CITY OF ALBUQUERQUE

**Re: Broadstone Promenade Phase 2
6400 San Pedro Dr. NE
Grading and Drainage Plan
Permanent CO – Not Accepted
Engineer's Stamp dated: 5-26-15 (D18D054A)
Certification dated: 12-14-15**

WEST
GRADING AND DRAINAGE PLAN

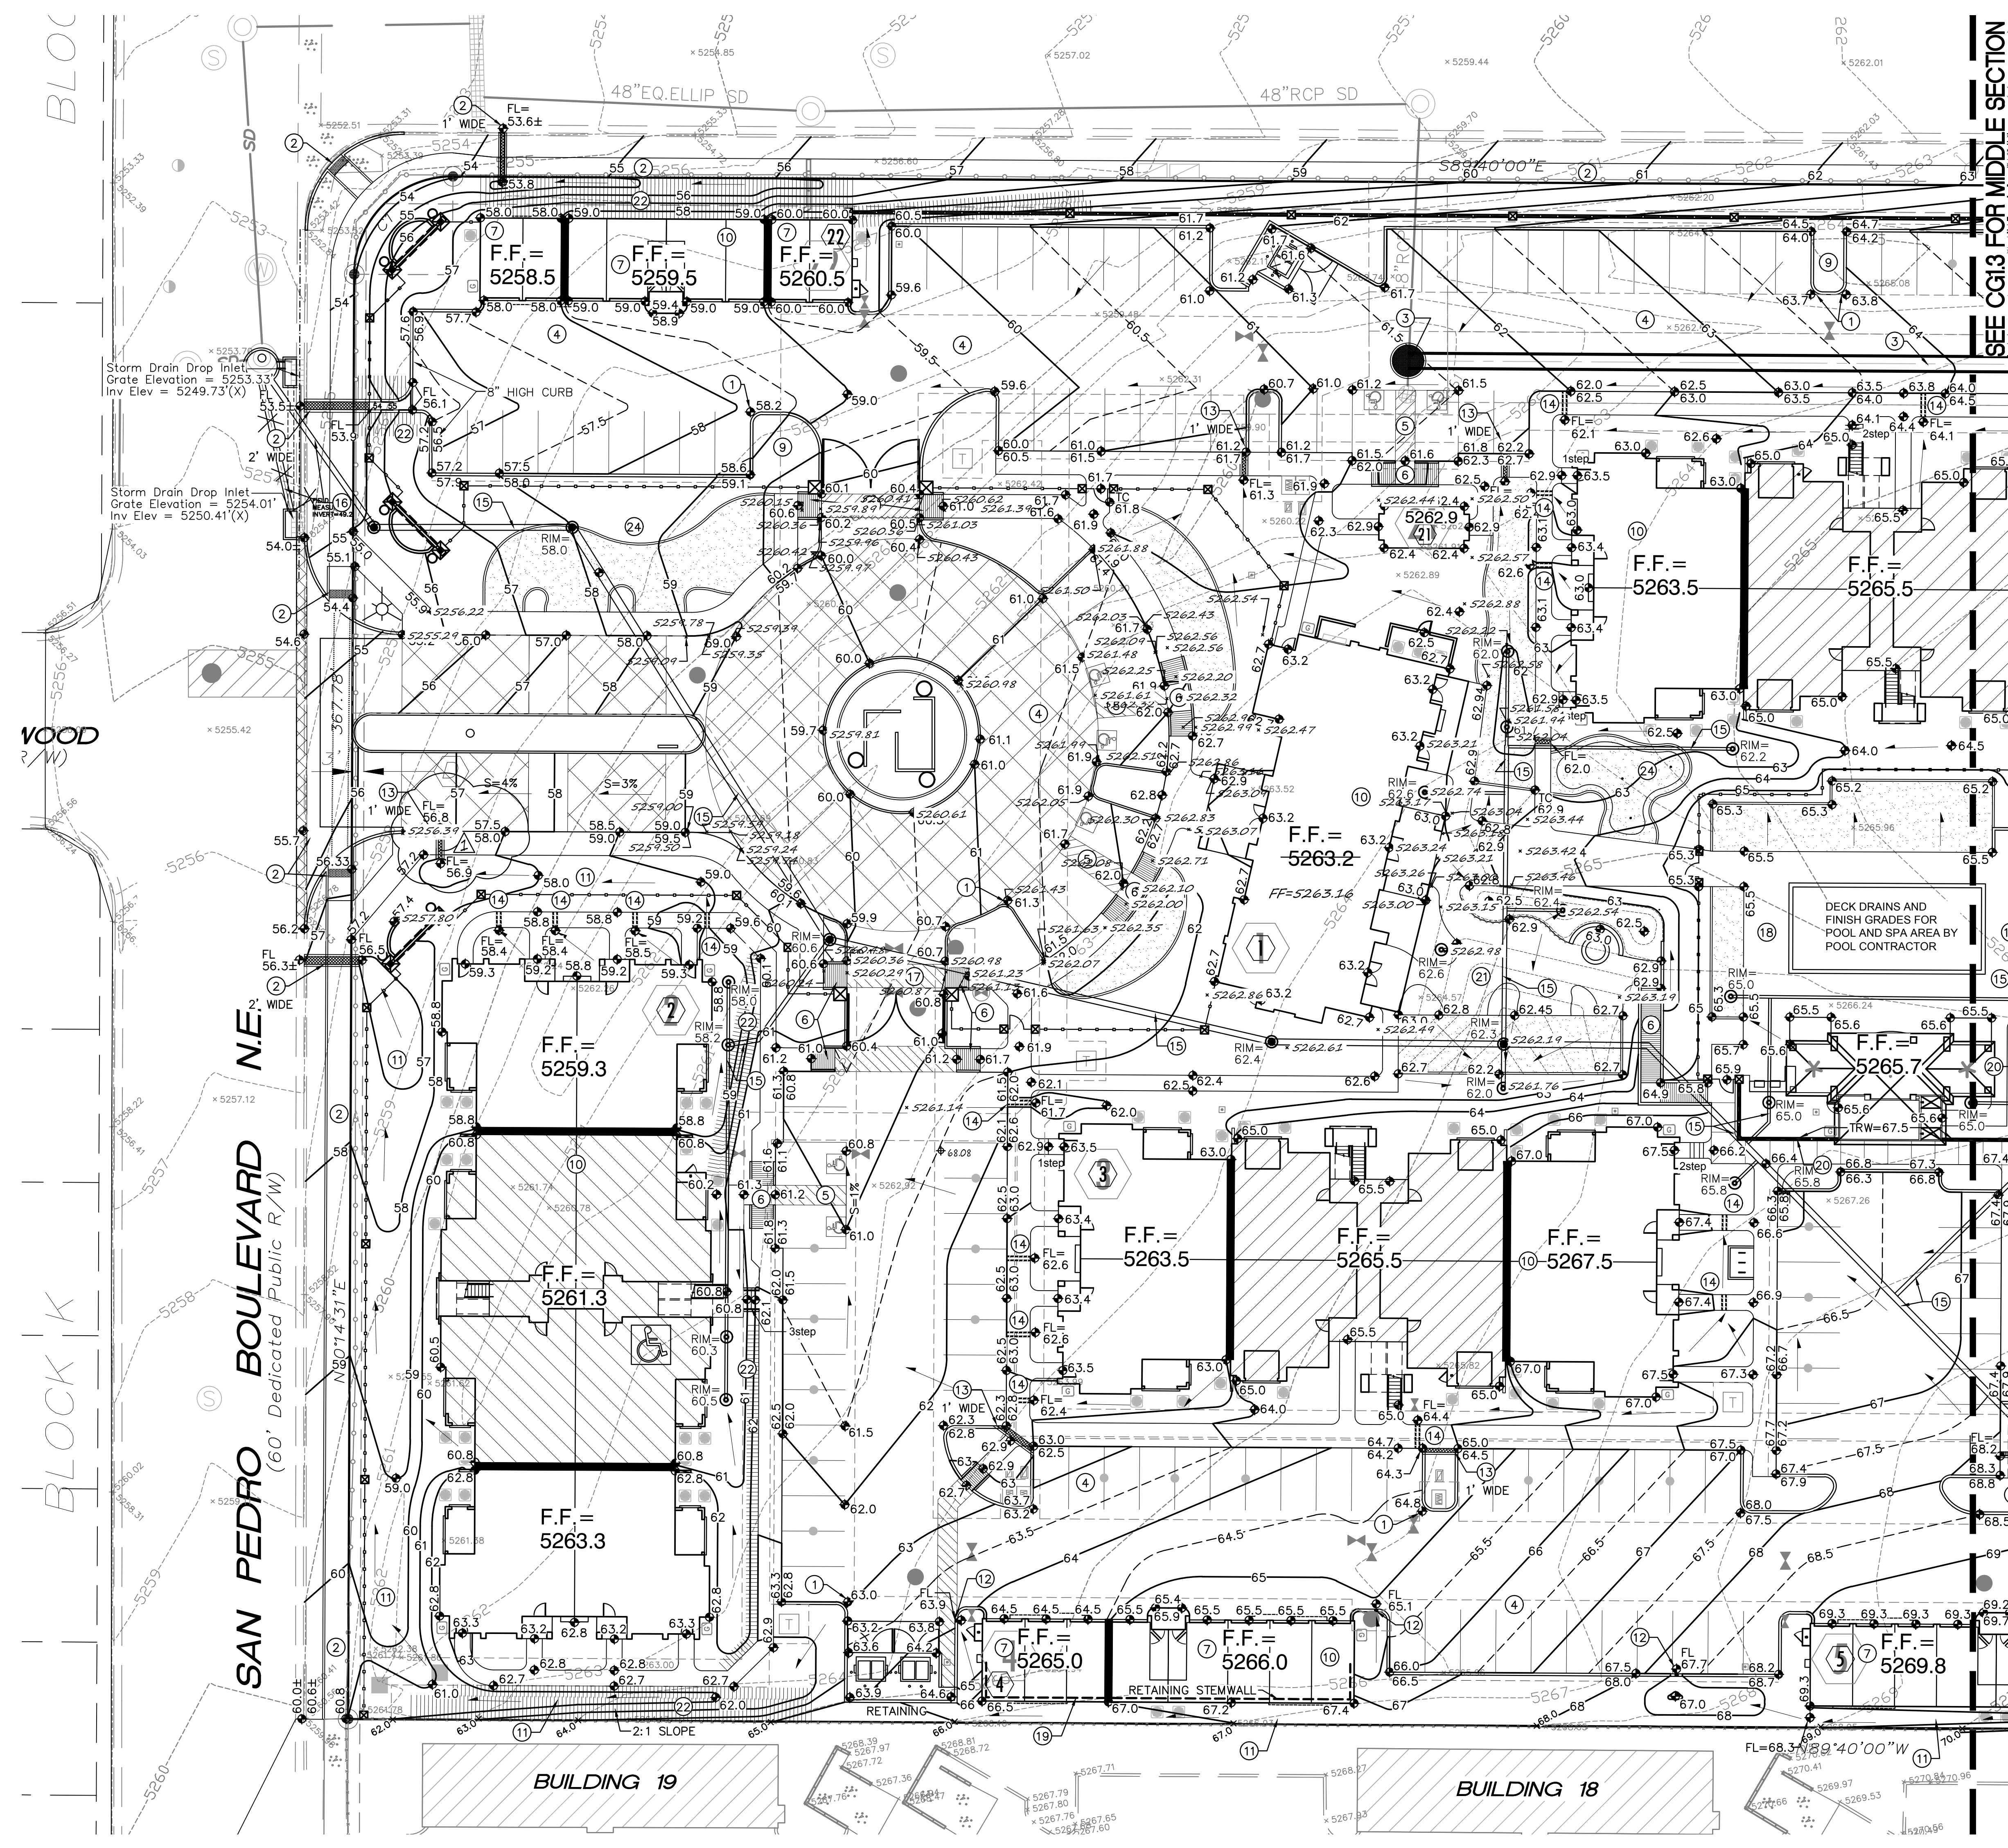
- When the CO PERM for Phase 2/Fitness Building & Pool Area was approved 8-26-15 the sidewalk culvert was overlooked. It is located at the SW corner of building 20.
